Reference No: 2018/62/91189/W

Site Address: 176, Laund Road, Salendine Nook, Huddersfield, HD3 3TY

Description: Demolition of existing bungalow and erection of new dwelling

DECISION – Full Conditional Permission

Drawn No.  
109

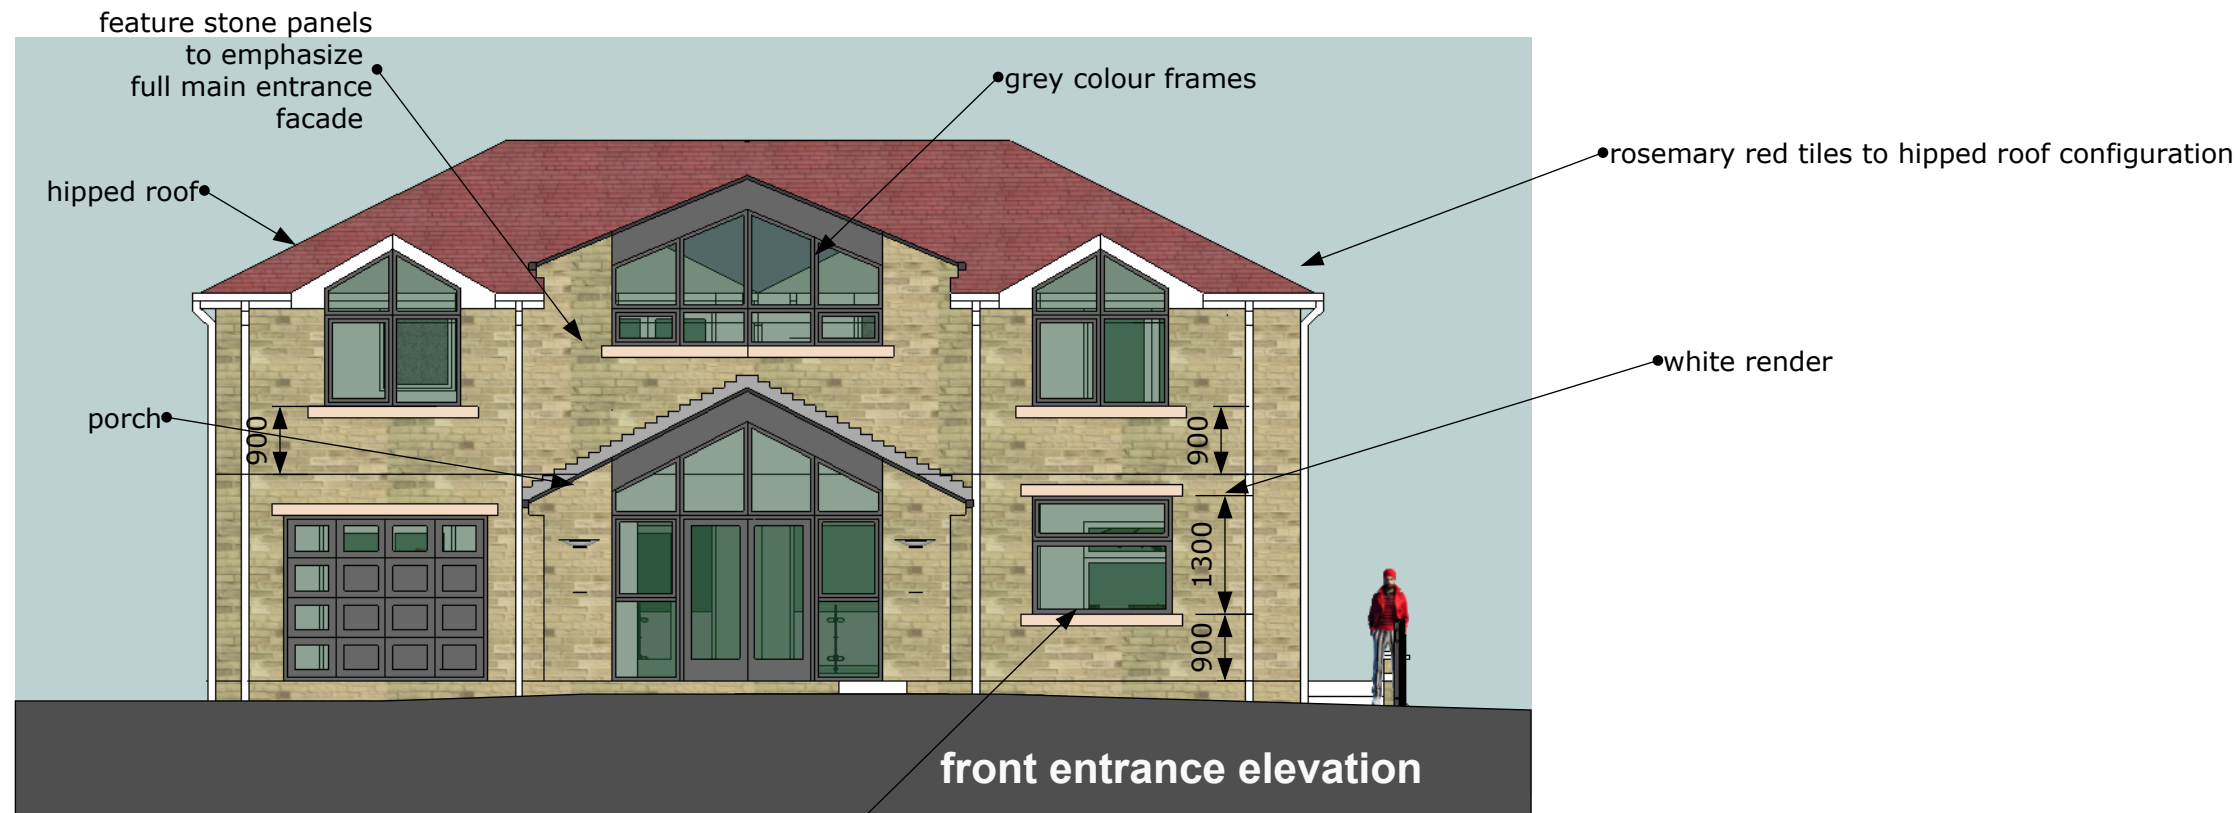
5. The development shall not be occupied until the 2 windows in the 'side 1 elevation' as indicated on Dwg no. 109 Rev F of the hereby approved have been obscure glazed (minimum grade 4). Notwithstanding the provisions of the Town and Country Planning (General Permitted Development) Order 2015 as amended (or any Order revoking or re-enacting that Order) the obscure glazing shall thereafter be retained.

6. Notwithstanding the submitted details, a 1.8 metre high obscurely glazed (minimum grade 4) privacy screen shall be positioned along the full side elevation of the raised terraced area facing No. 168 Laund Road, as indicated on 'side 1 elevation' on Dwg no. 109 Rev F, before the raised terraced area is first brought into use. The obscure glazed shall thereafter be retained in accordance with the requirements of this condition.

Drawn No.
107

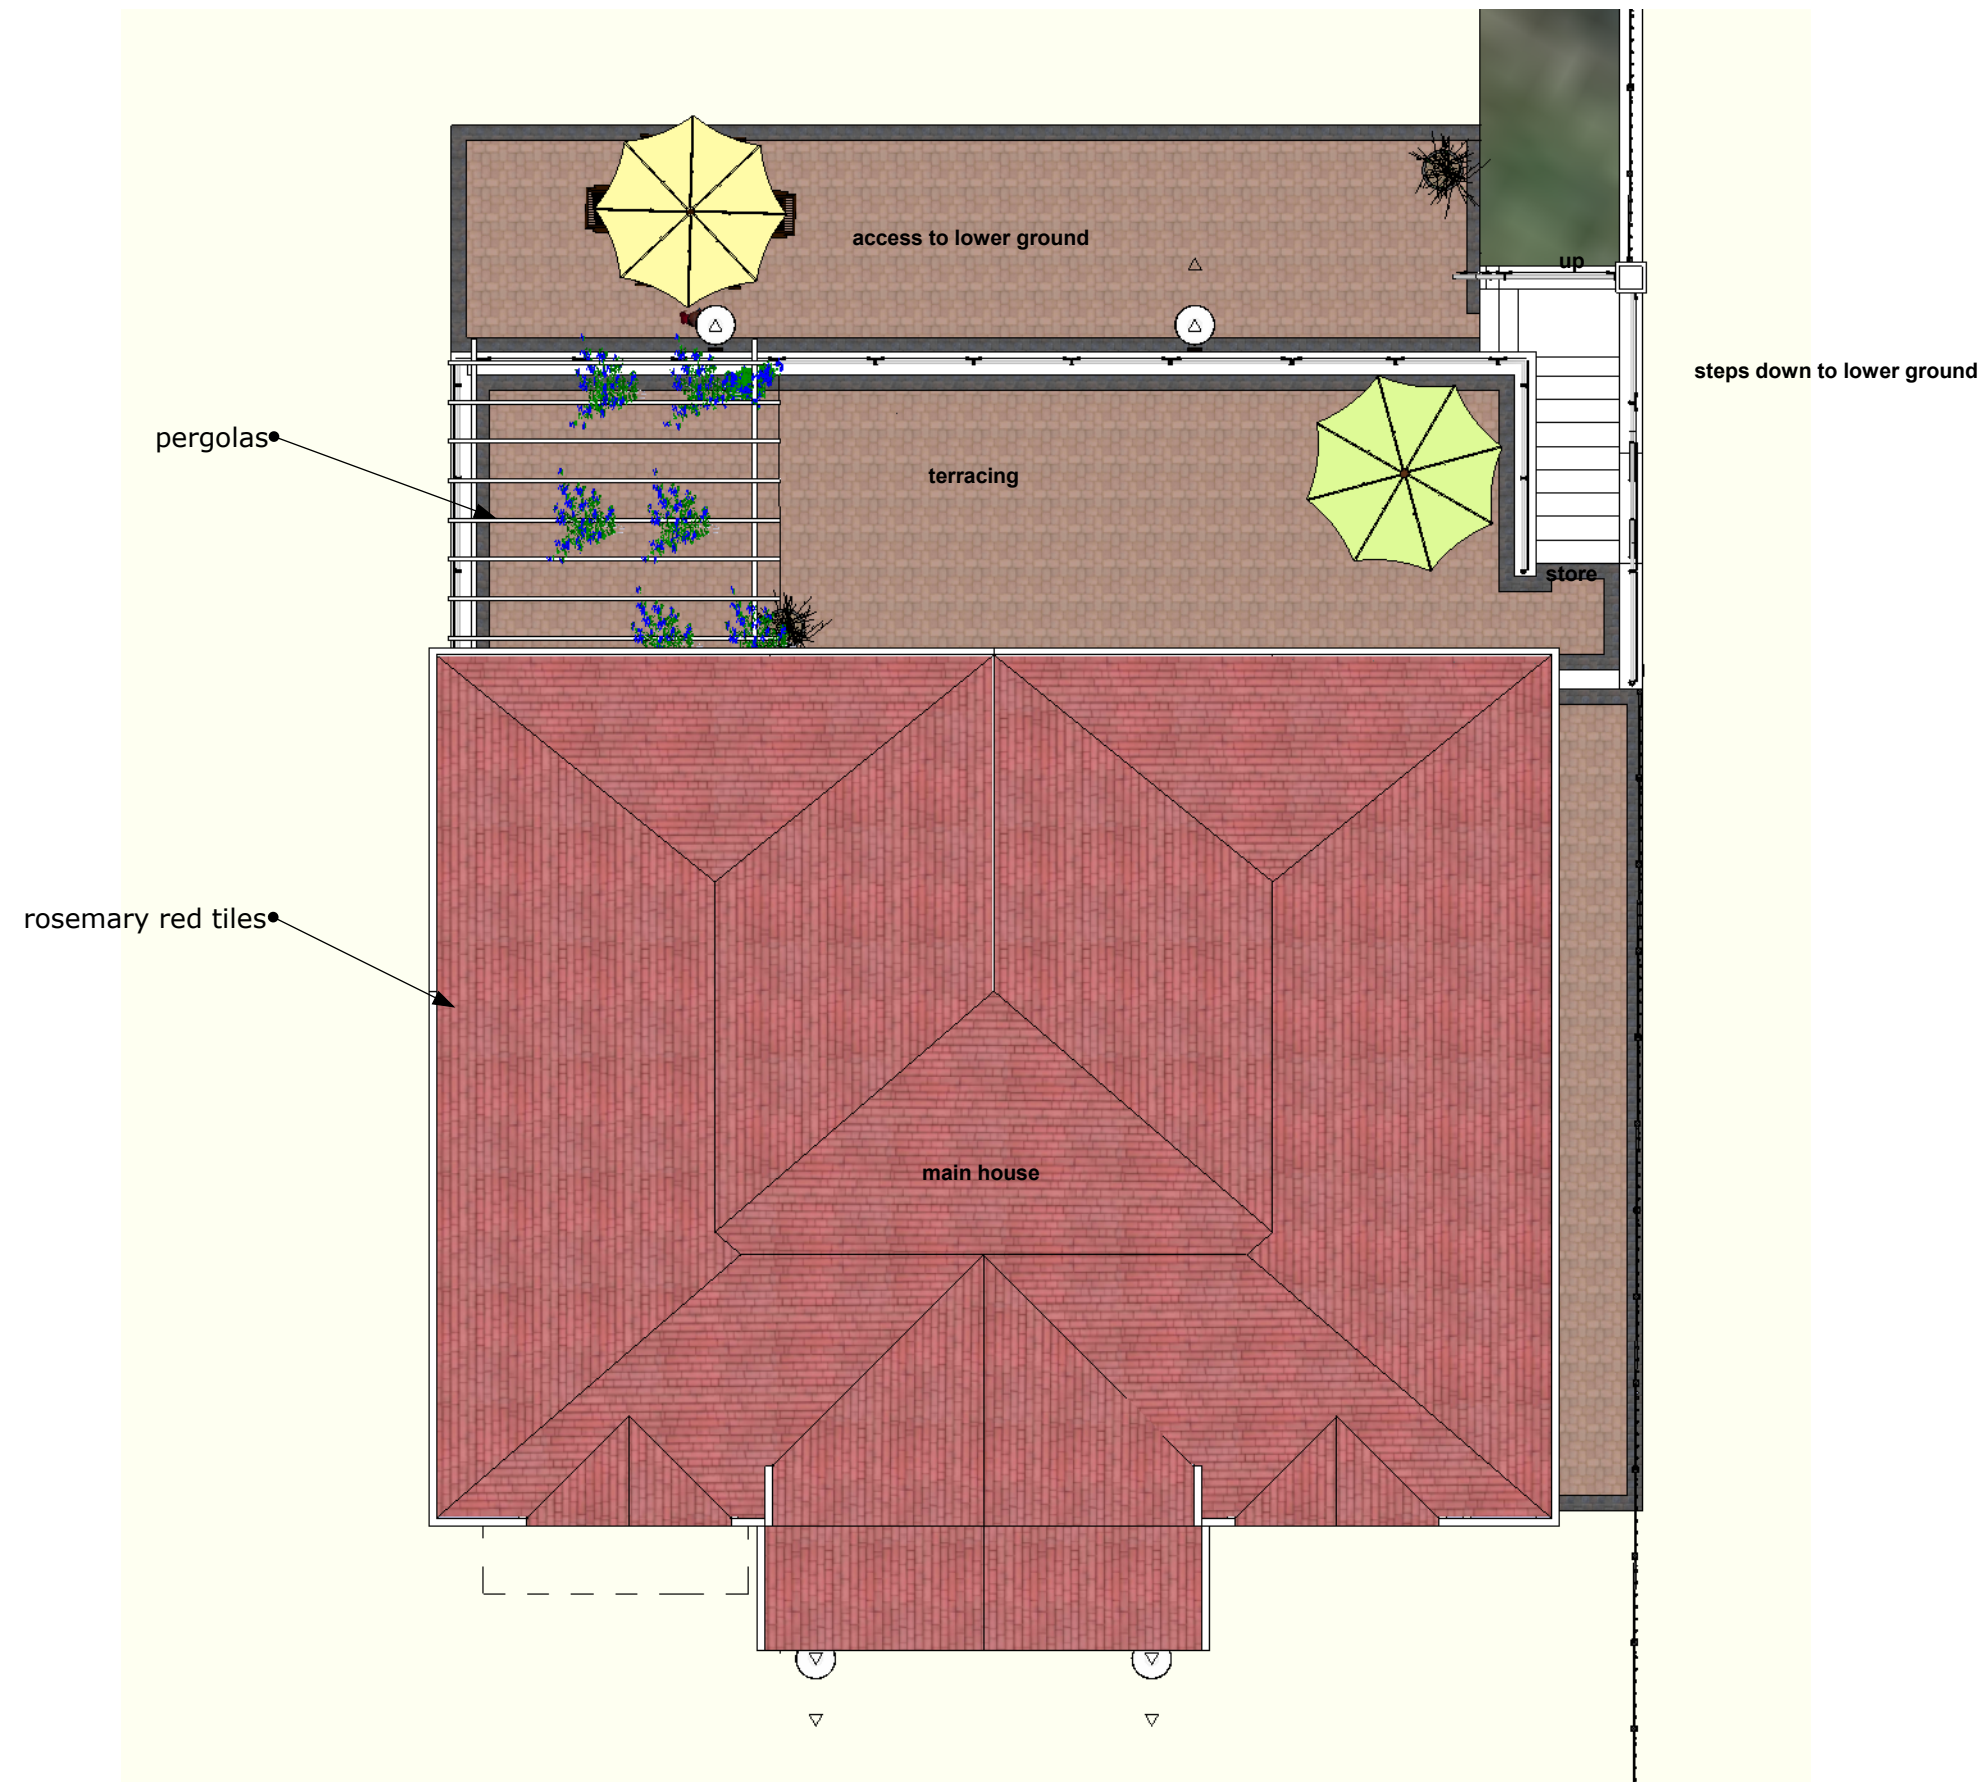
8. The roof covering shall be plain grey tiles to harmonise with those used at 168 Laund Road.
